K. TROTMAN- ARCHITECTURAL SERVICES

Your Ref; FP/153/11/

8th September 2011

PROPOSED DORMER BEDROOMS

PROPOSED EAST ELEVATION

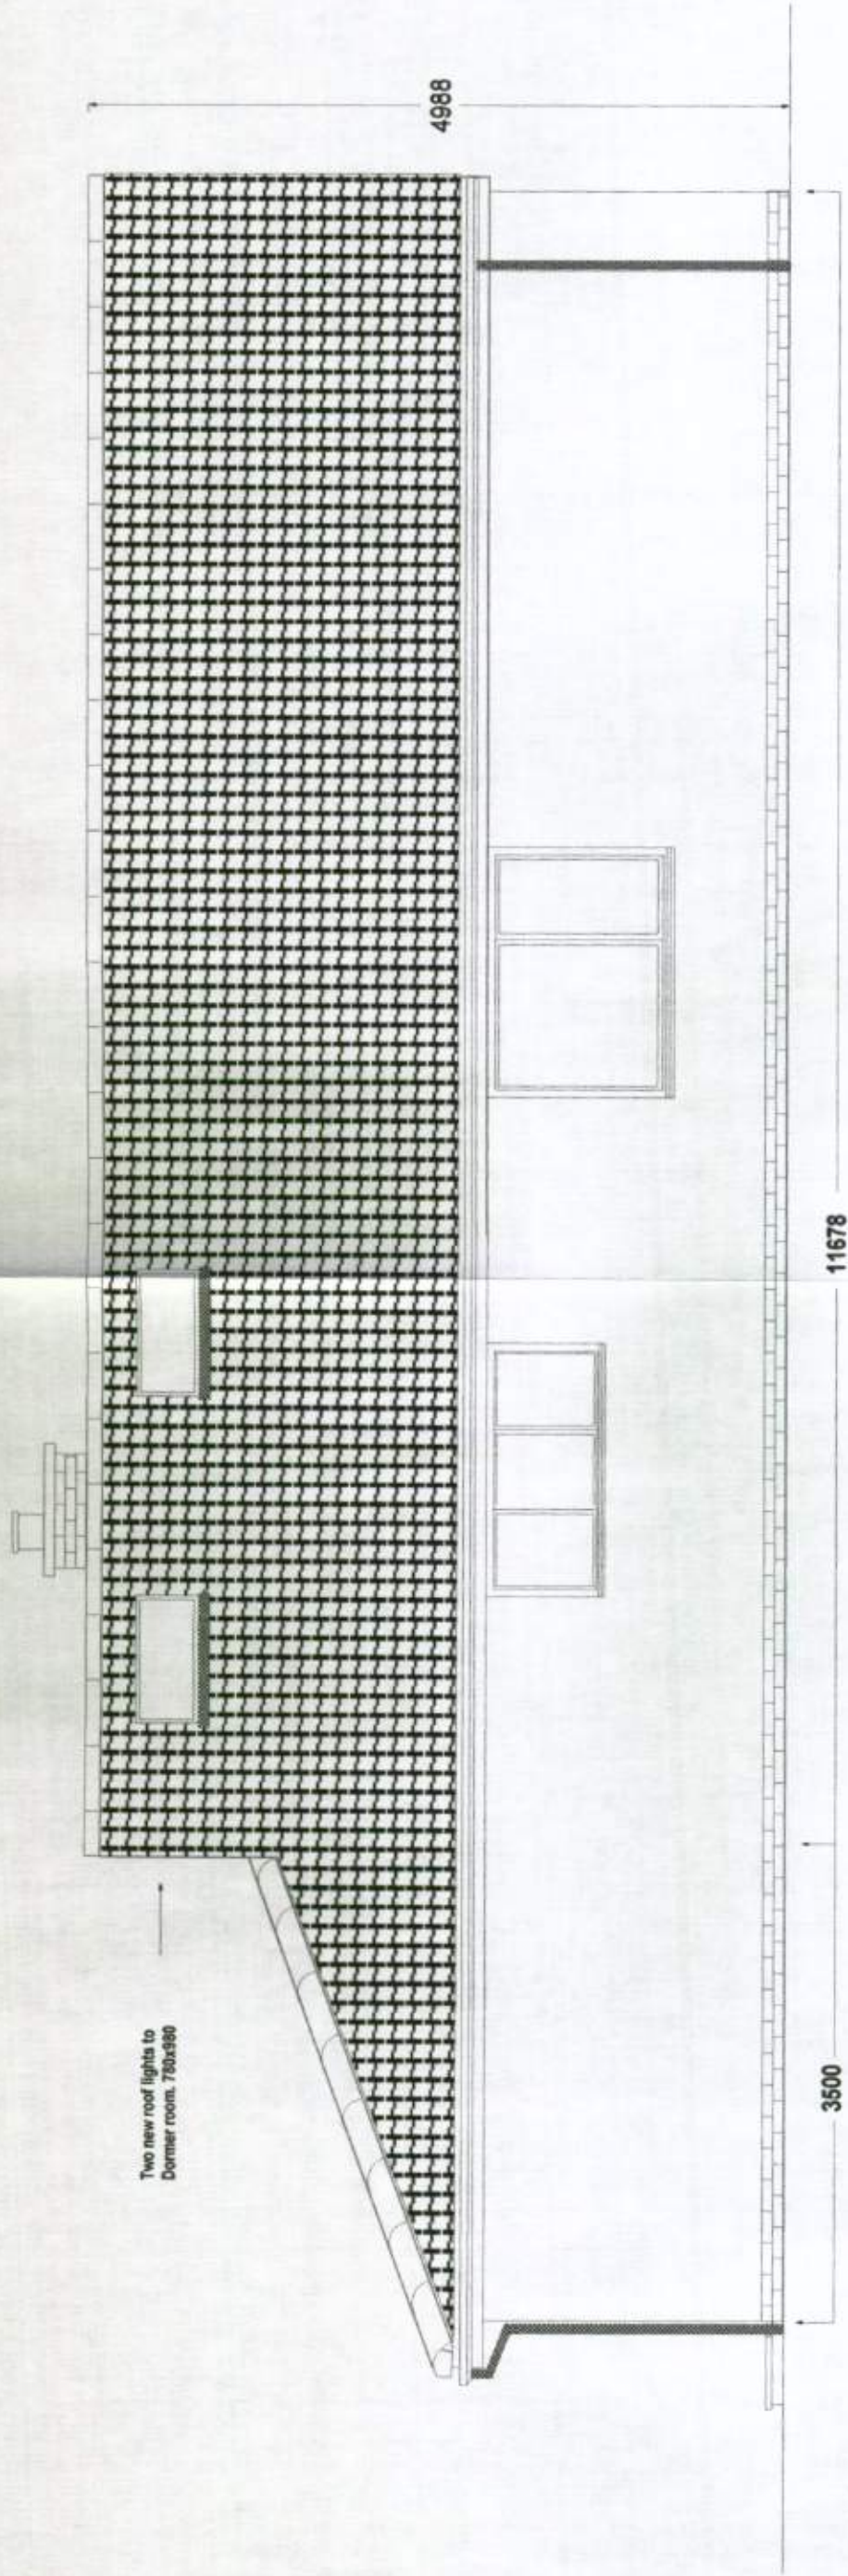
Revised East elevation, showing additional roof light to compensate for a smaller window on the West elevation.
